Subject: Rezoning Petition Review

Rezoning Petition #: 21-257

Location of Property: Approximately 52.67 acres locate on the west side of Amos Smith Rd and southeast side of Old Dowd Rd, west of I-485.

REZONING
NOTES

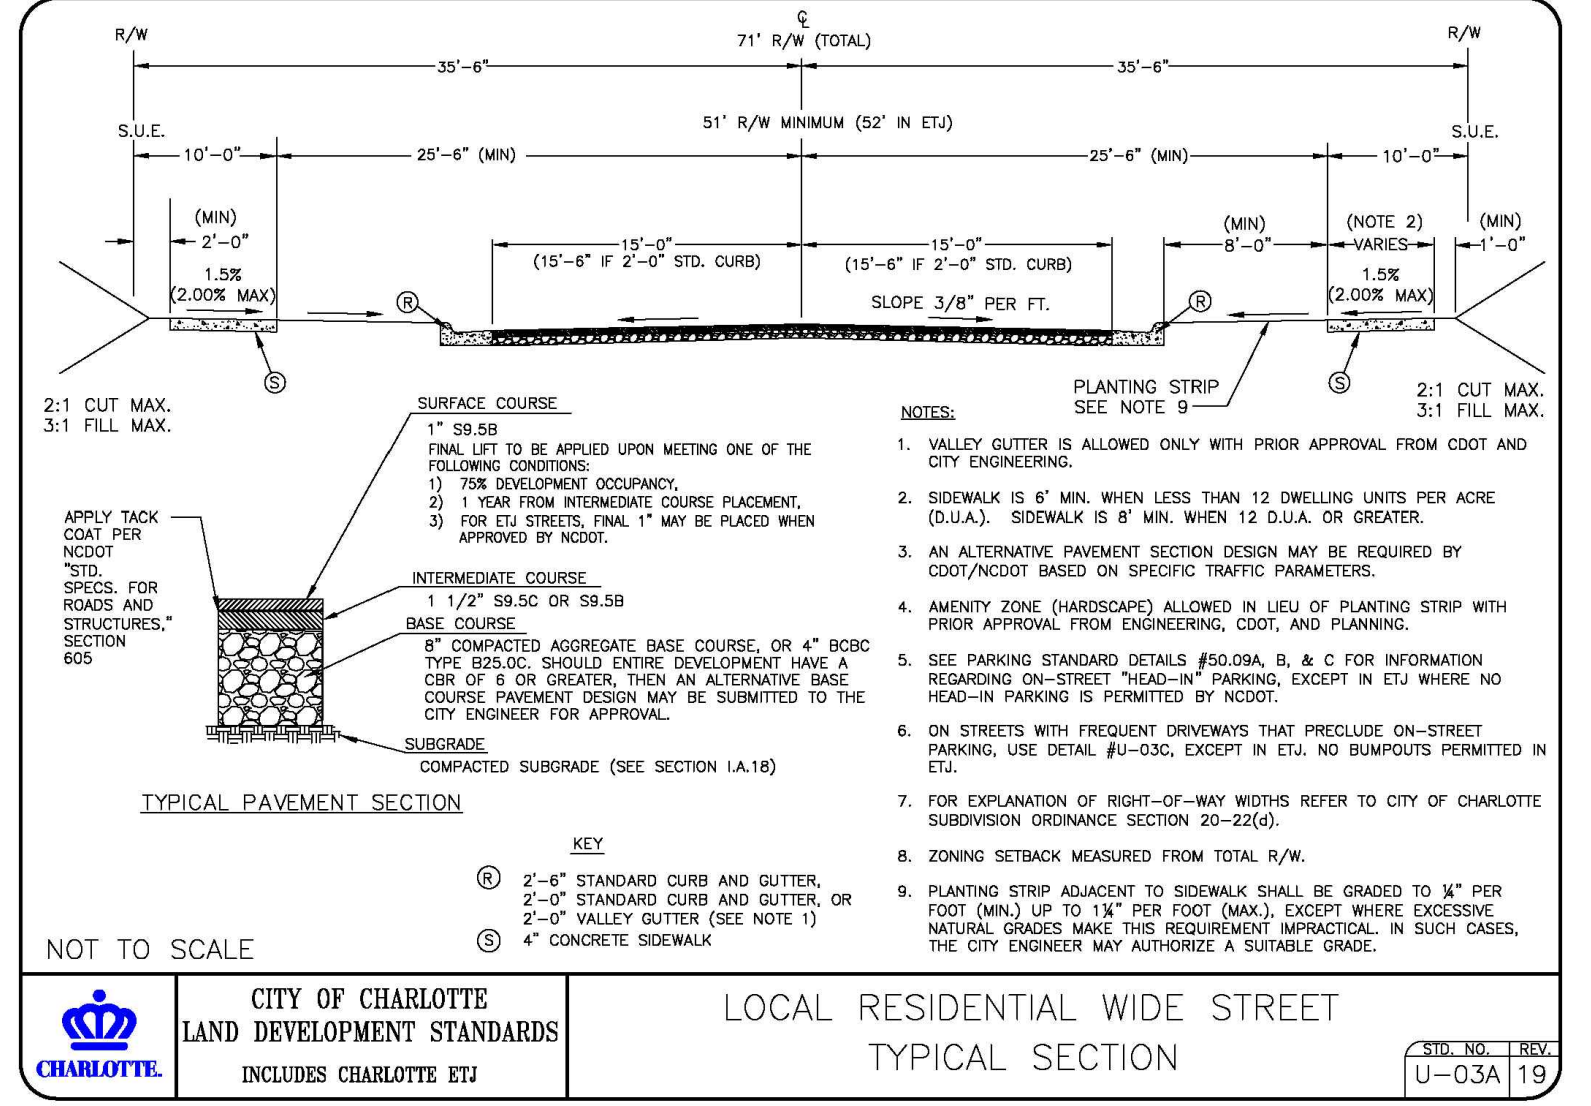
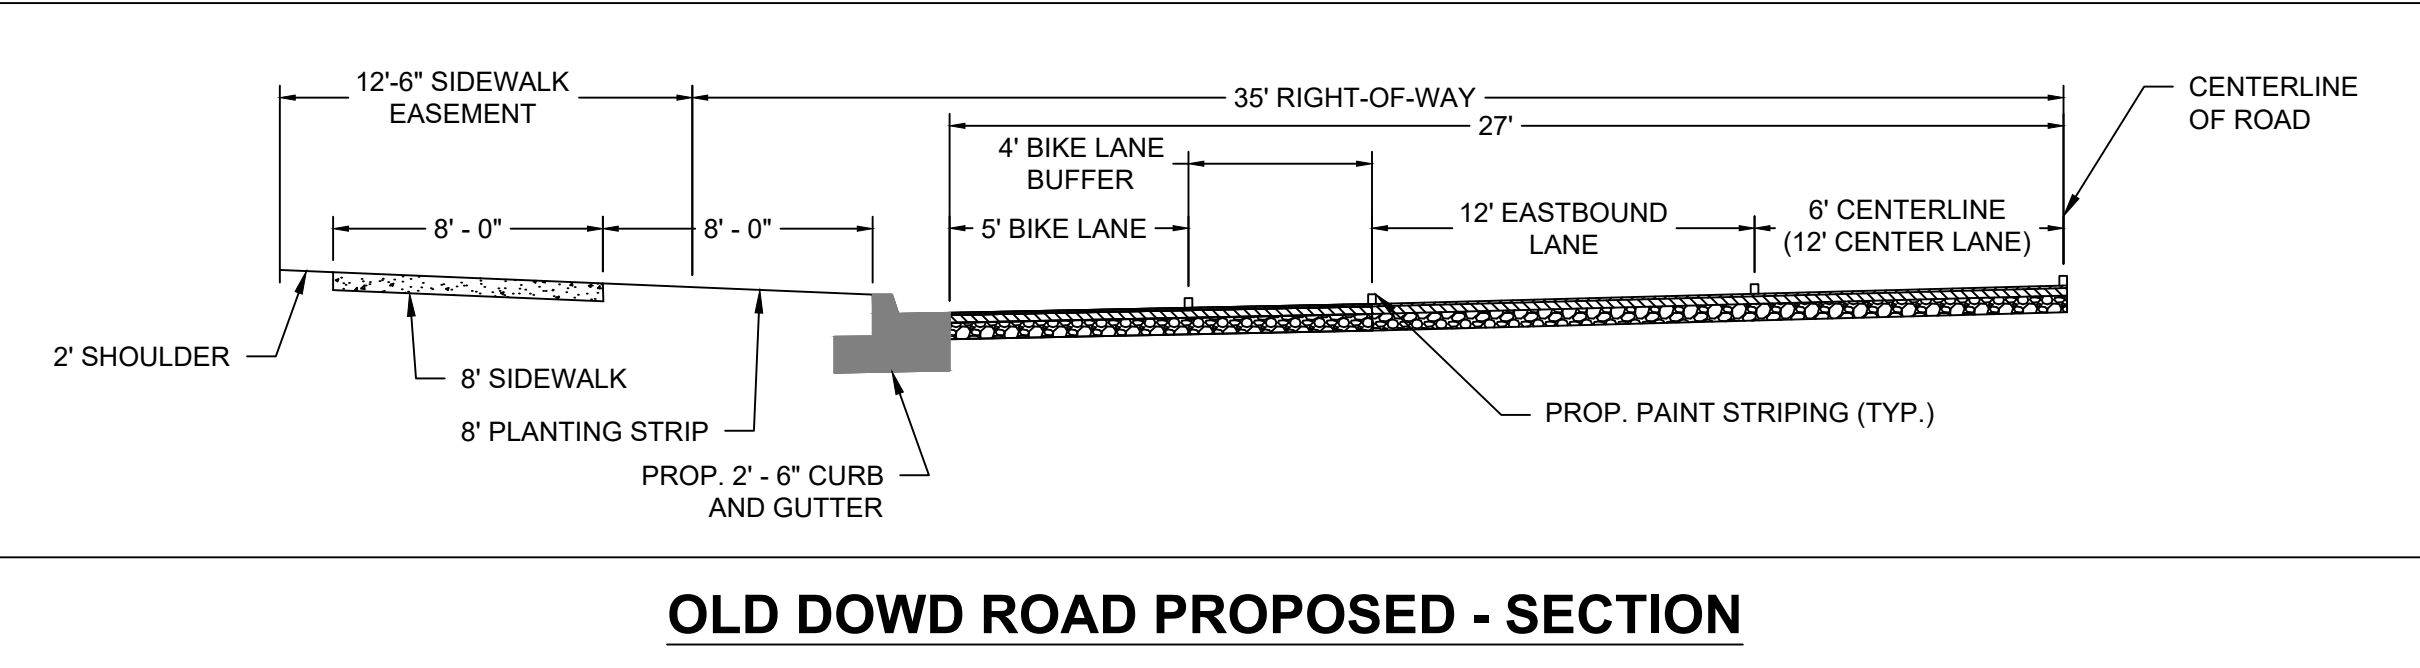
Please include the following note under Environmental Features: *“Development within any SWIM/PCSO Buffer shall be coordinated with and subject to approval by Charlotte-Mecklenburg Storm Water Services and mitigated if required by City ordinance. Petitioner acknowledges intermittent/perennial stream delineation reports are subject to review and approval upon submission of development plans for permitting and are not approved with rezoning decisions.”*
